MEMORANDUM

SUBJECT: SP-20-008 – Homestead North - Sterling Ranch
Second Submittal

Engineering Division

HOMESTEAD NORTH AT  
STERLING RANCH  
EARLY GRADING & EROSION  
CONTROL PLAN

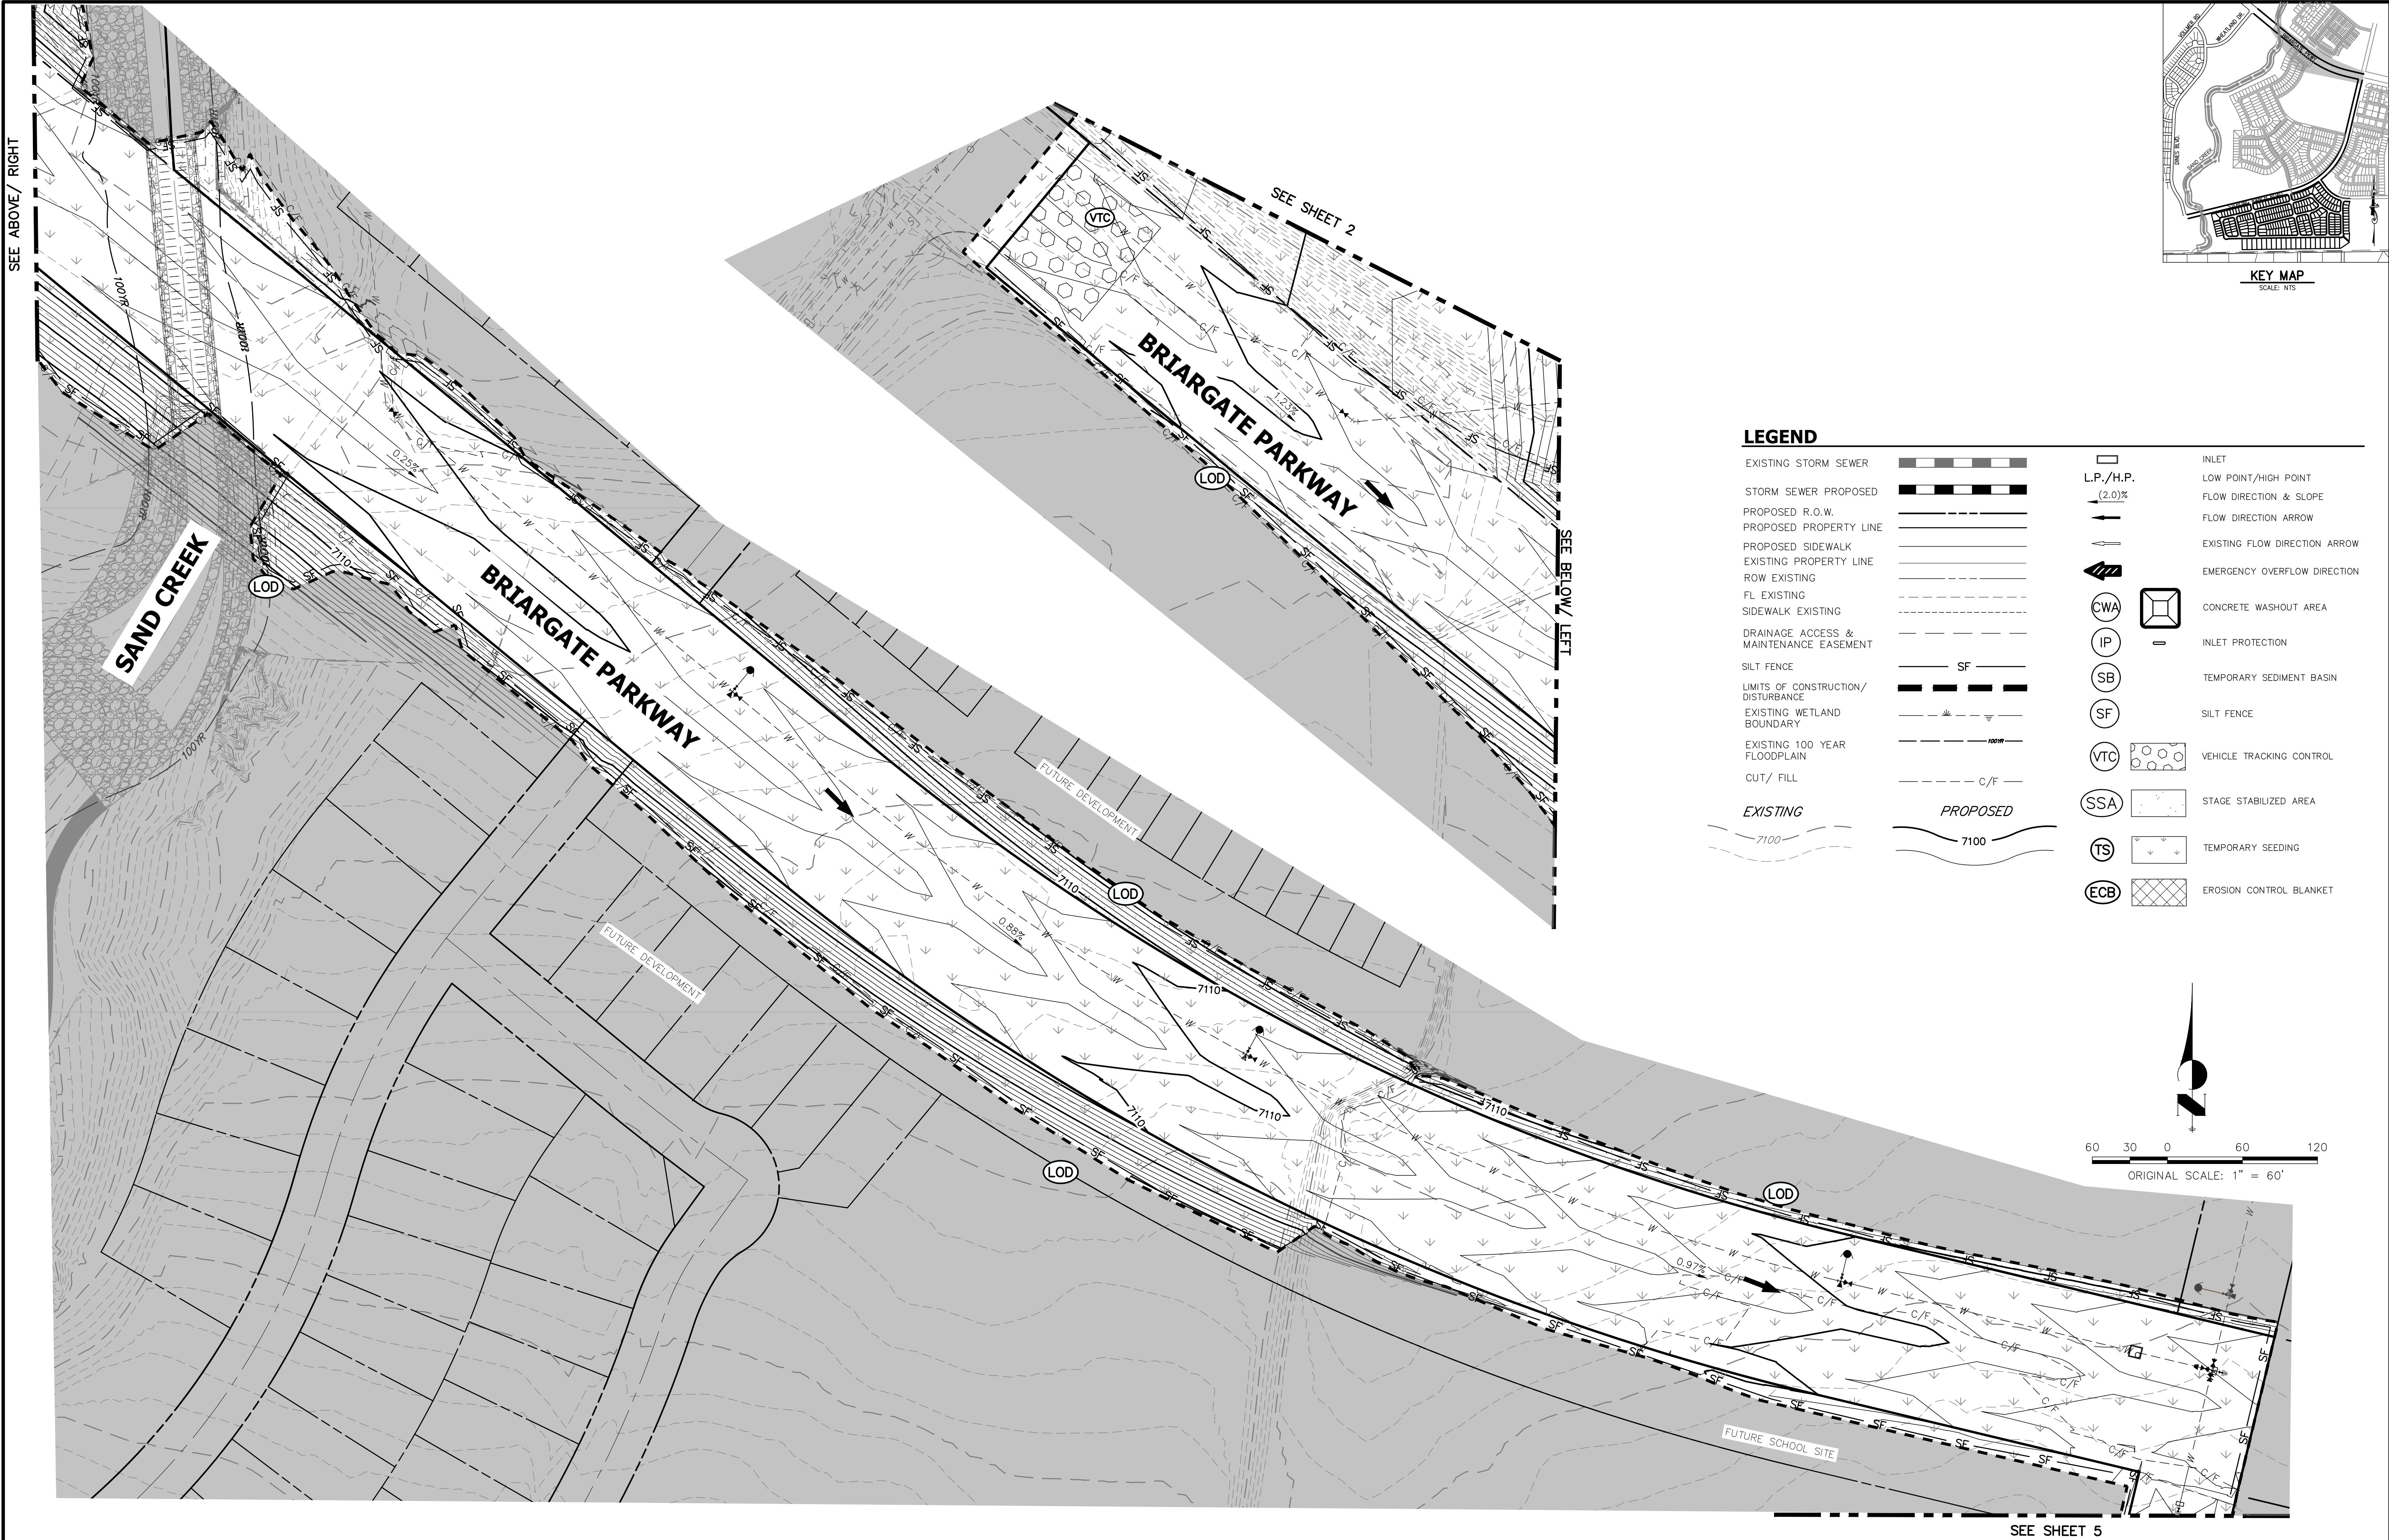
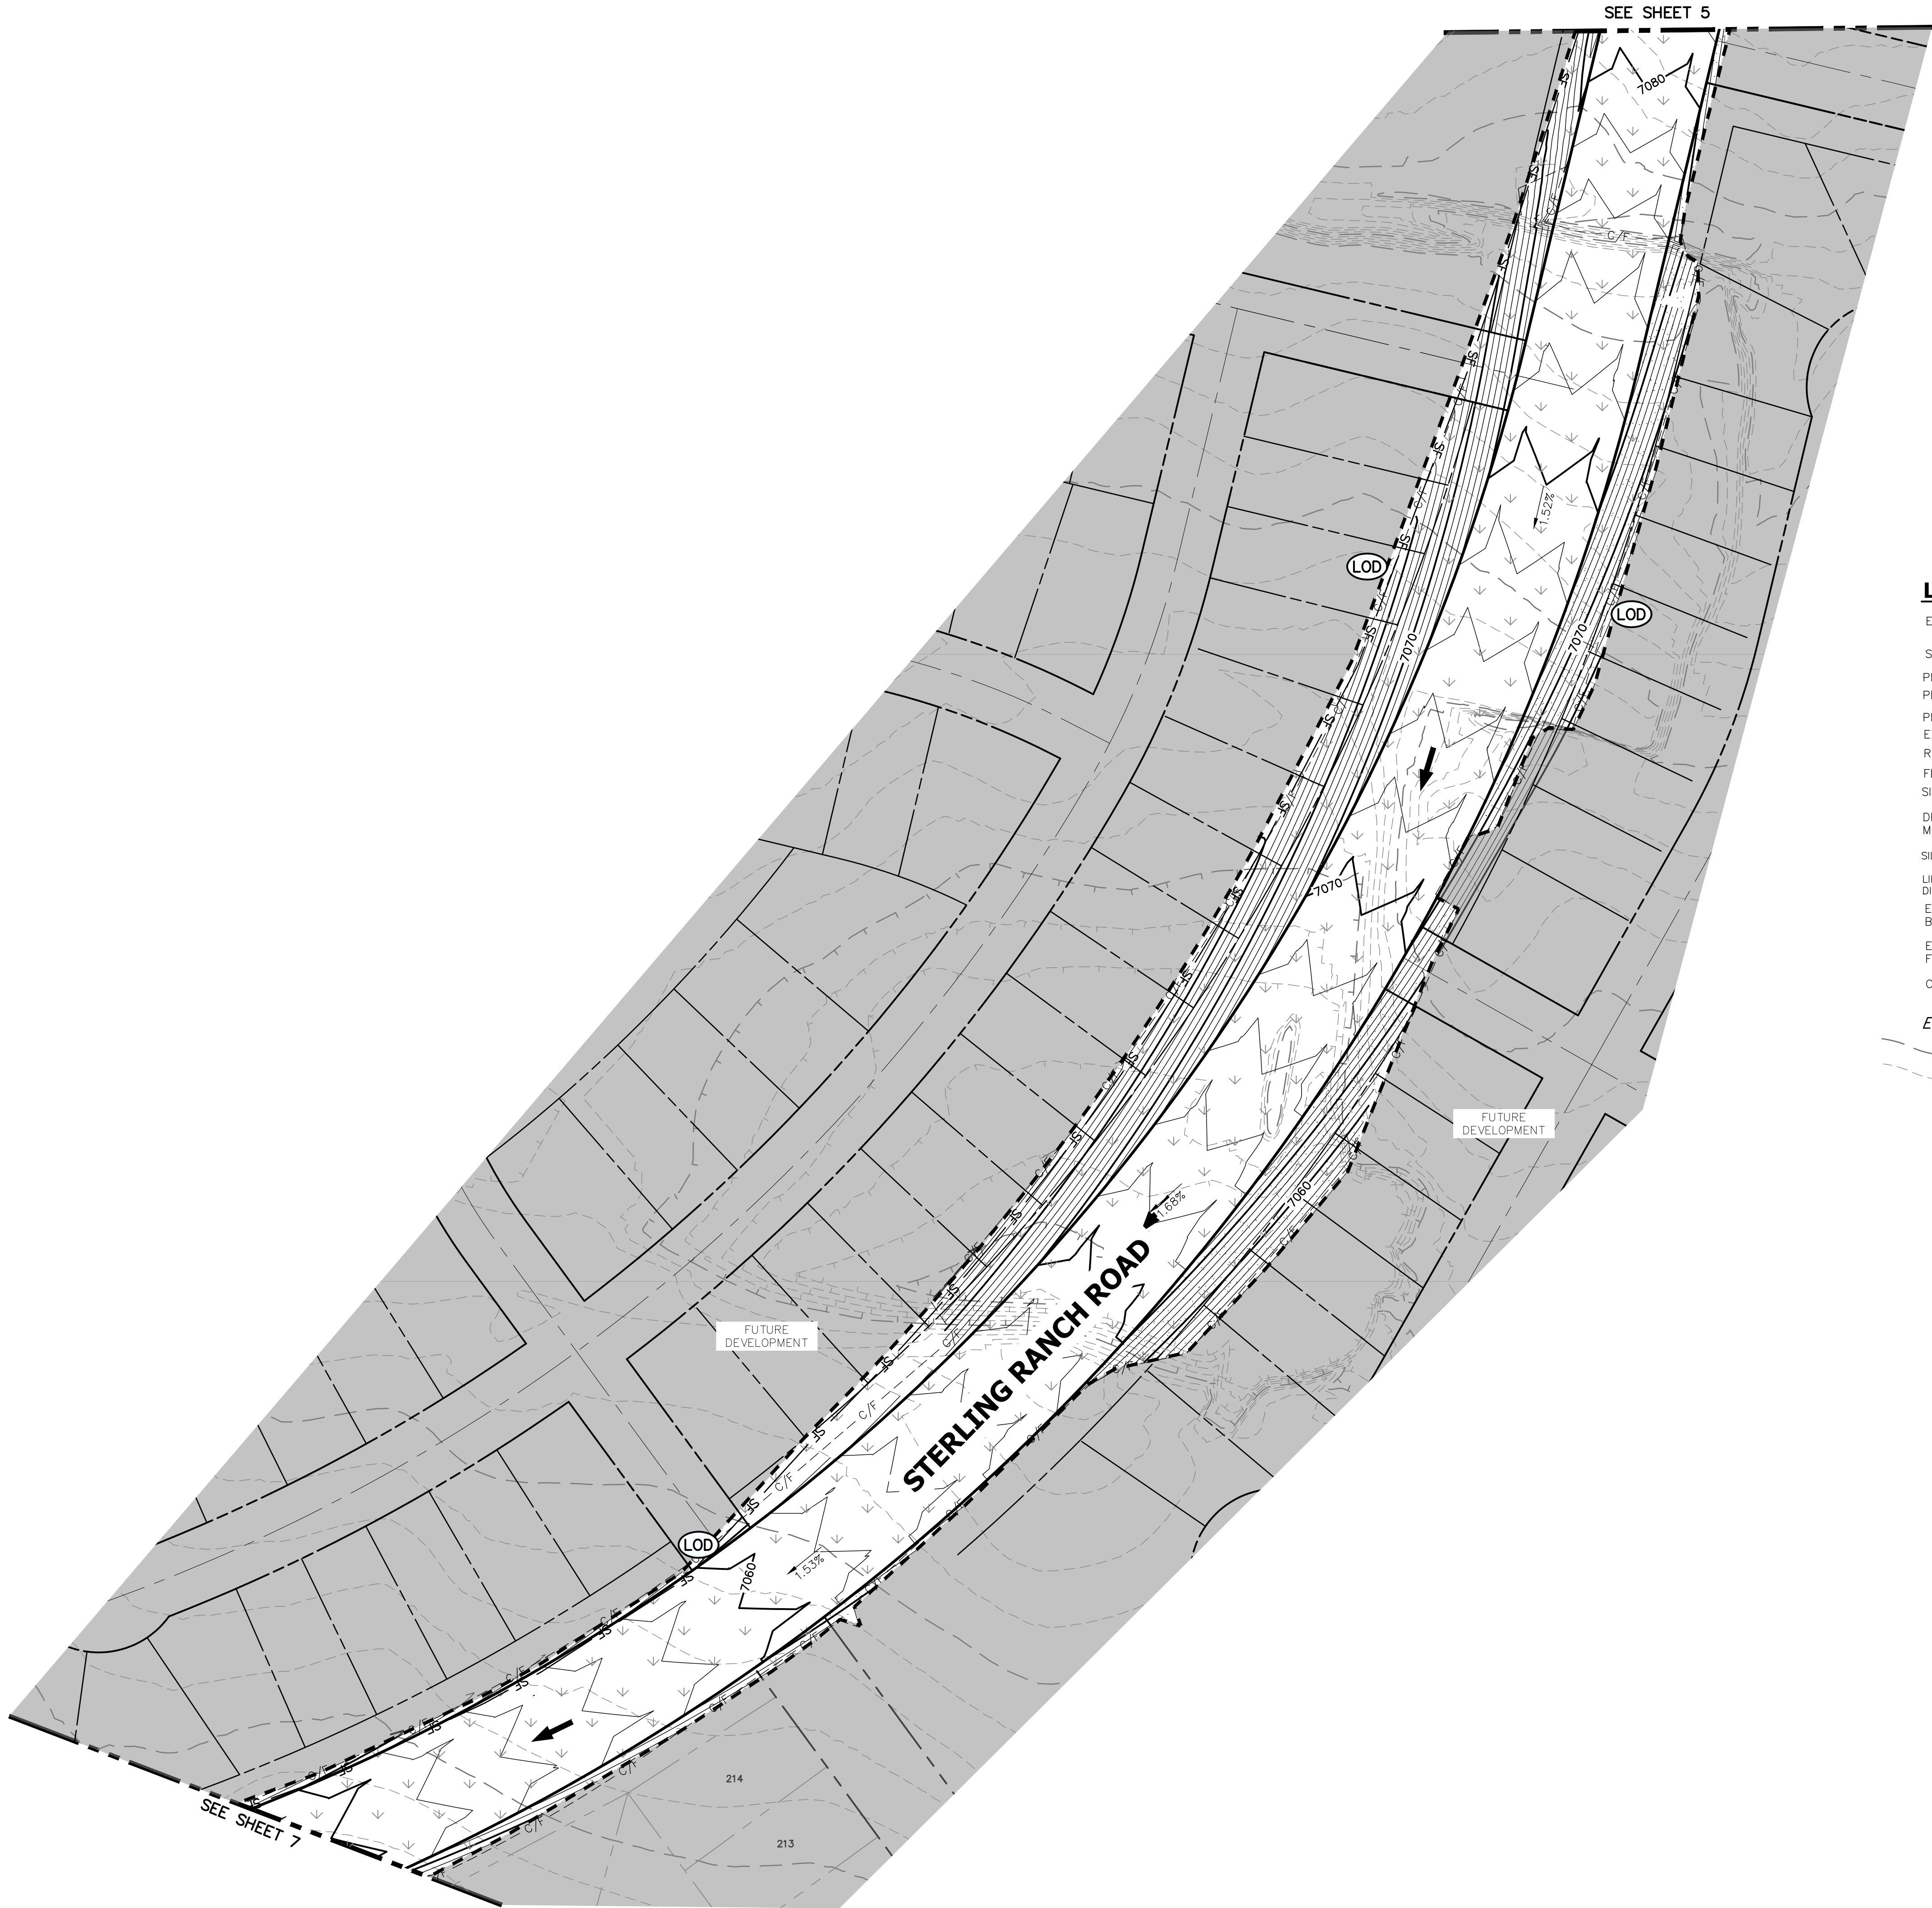
- 6. Note: **not all** inlet and storm drain calculations were checked in detail with this review.
- 7. Also provide a drainage plan for the interim pre-development site grading not showing curb and gutter and showing temporary facilities. This should match the grading shown on the early grading and erosion control plan. **Partially resolved; see redlines.**

- a. **Note: this submittal of the GEC plan was not reviewed by PCD-Engineering pending revisions to the PDR and preliminary plan and review of the revised Sand Creek channel plans.**
 - b. **Address how the potentially unstable areas along Sand Creek at the northeast corner of the site will be stabilized.**
2. The maintenance access road shown along the west side of the channel runs in and out of the grading area. This road needs to be completed to criteria (slope, width, etc.) with the site grading to avoid regrading stabilized areas next to the channel. It needs to avoid future wetland mitigation areas and unstable areas. **(see related comments above and PDR redlines)**
